Date: 23-Oct-2018
Our Ref: 2018/92114

**Application for Approval of Details Reserved by Condition
Town and Country Planning Act 1990
Planning (Listed Buildings and Conservation Areas) Act 1990**

**Discharge conditions 3, 4, 5, 13, 20, 24 on previous permission 2016/92041 for demolition of
existing buildings and erection of 3 dwellings
Poplar Farm, Bristfield Road, Bristfield, WF12 0PA
Application Number: 2018/92114**

Drawing No. 1541_14_B

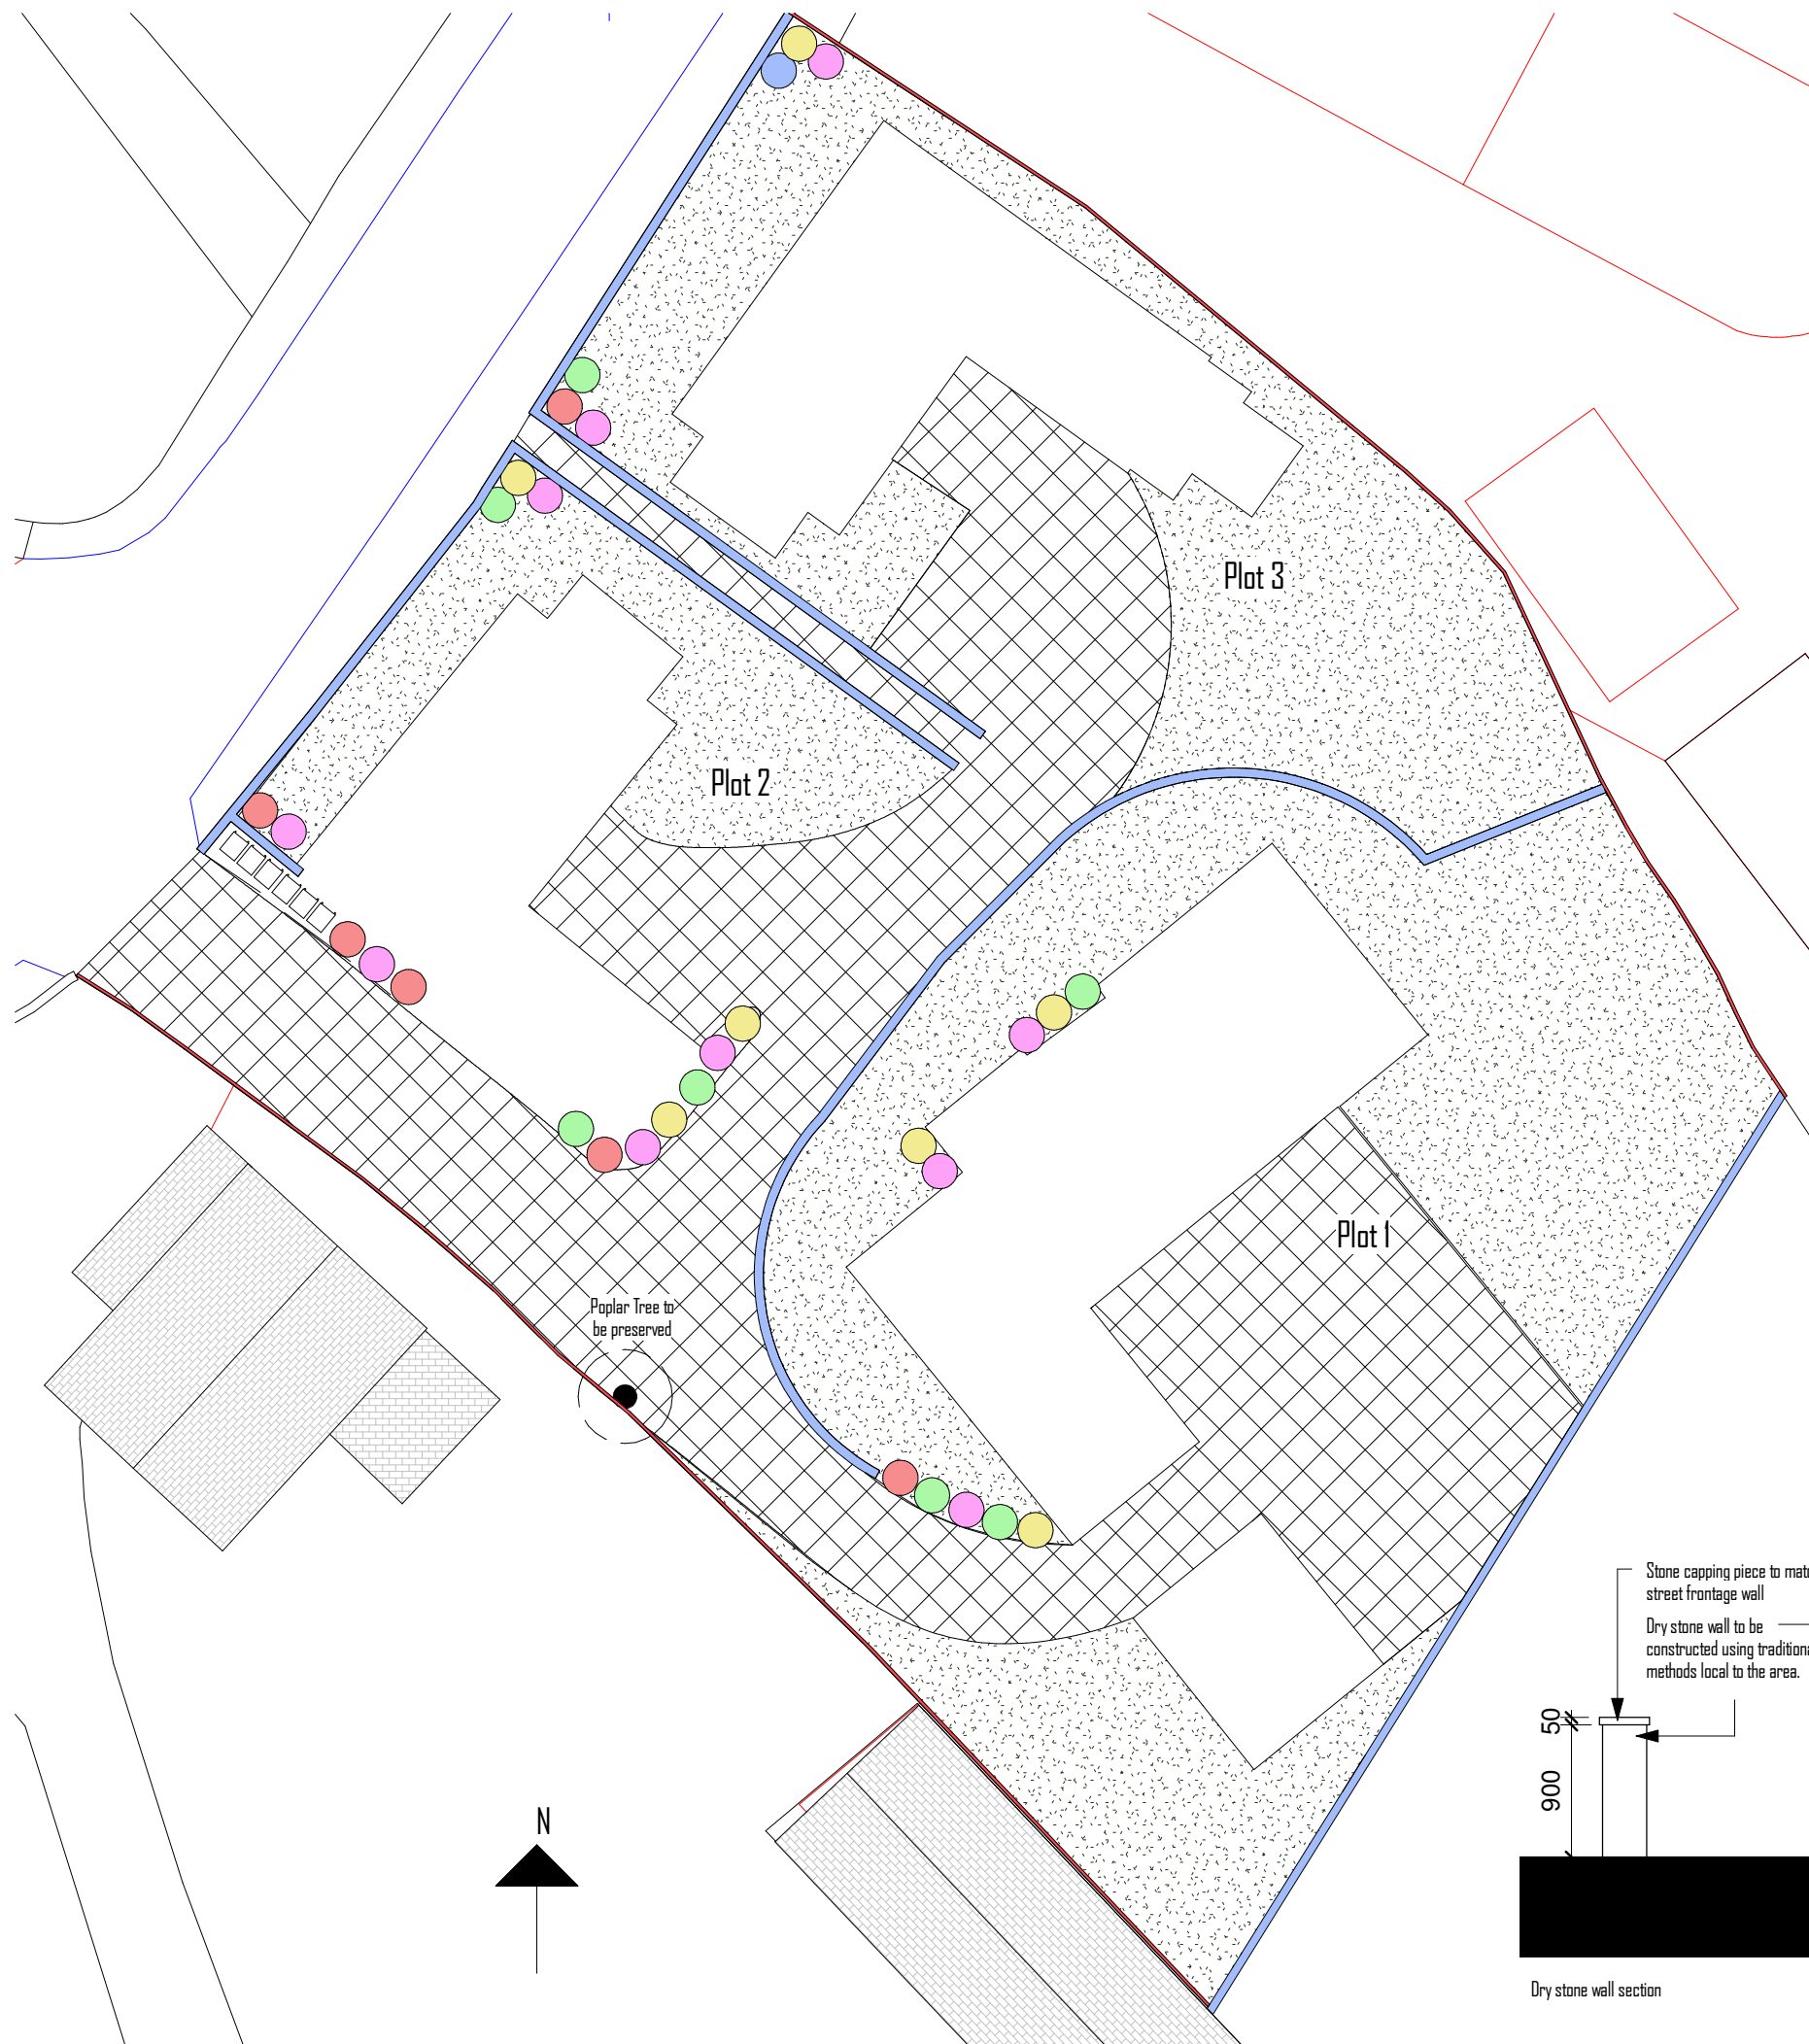
- Drawing 1541_14_B landscaping Plan

These details are acceptable for the purposes of condition 13 subject to the following:

- Notwithstanding the sections shown on the above drawing the boundary walls shall be drystone with a traditional coping and of the same stone agreed under condition 4 above. If any other material is to be used this must be agreed with this Authority beforehand.
- The boundary treatment shall be erected maintaining the visibility splays required under condition 10 of the planning permission.

**Drawing No.** 1541\_14\_D

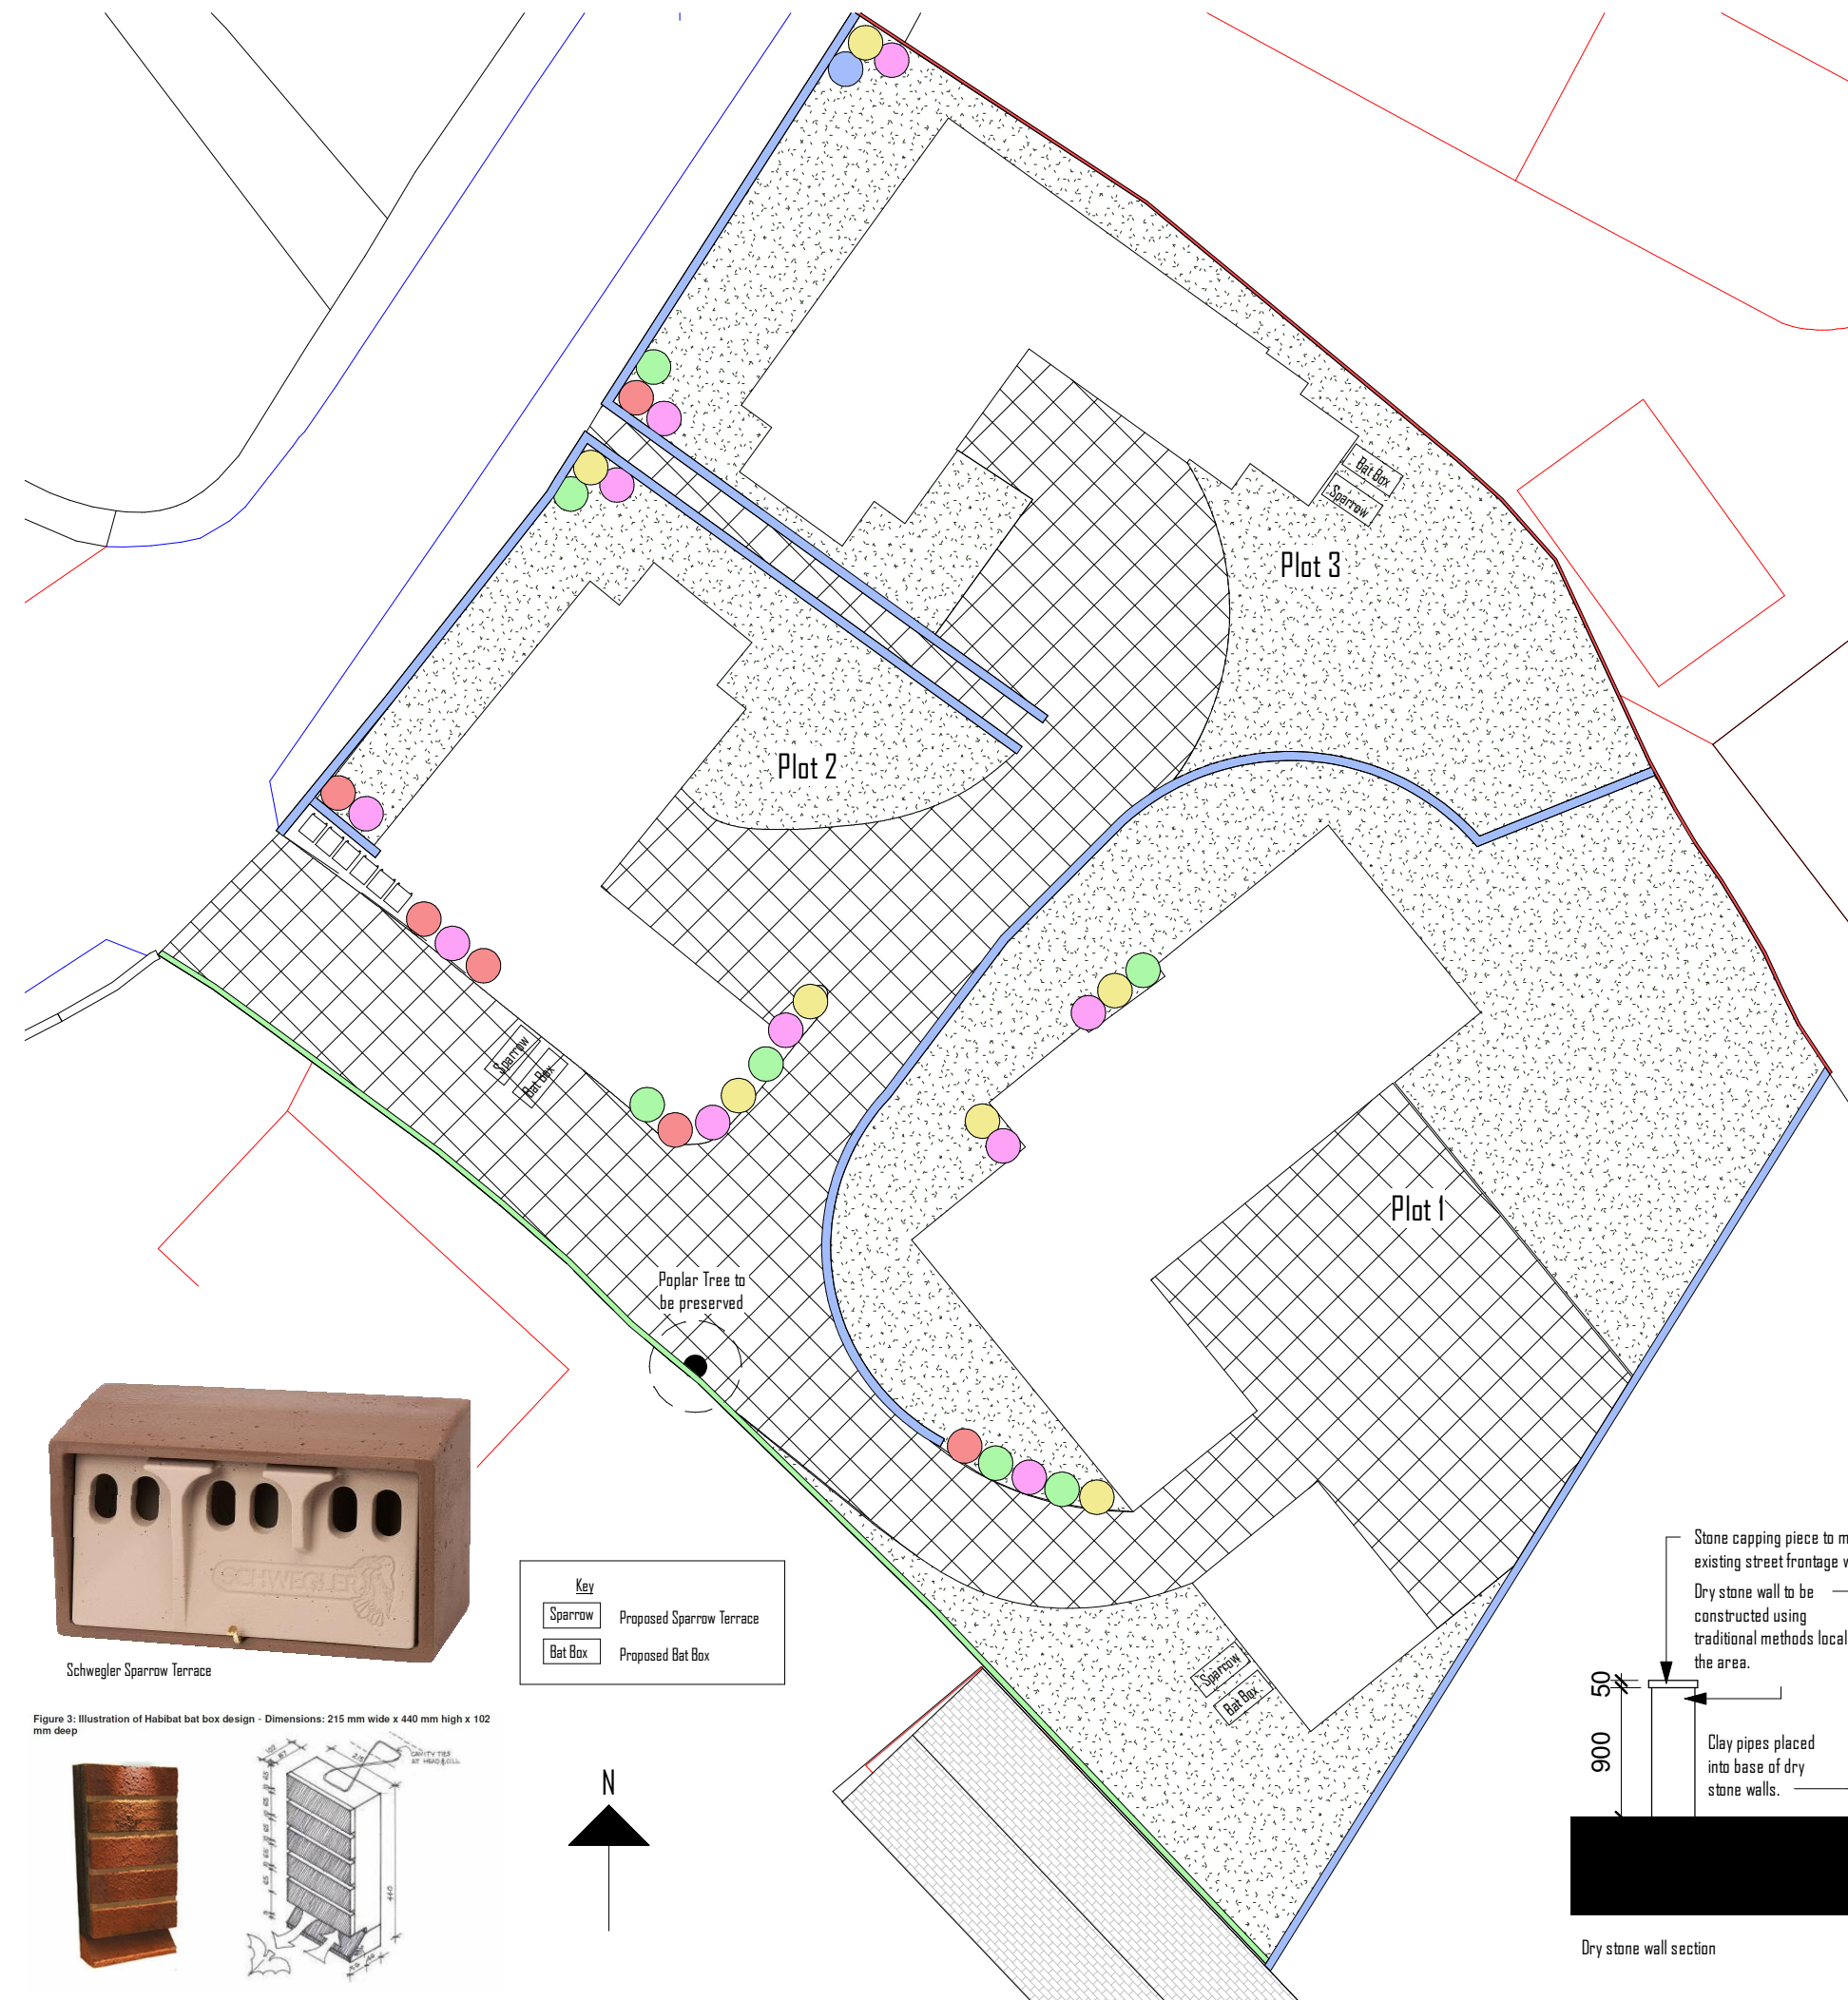
As noted in my e-mail of 22 August 2018 the submitted Landscape Management Plan does not address ecological issues. In such circumstances the condition cannot be discharged. These details can be submitted as part of the current application but are required within three weeks from the date of this letter.
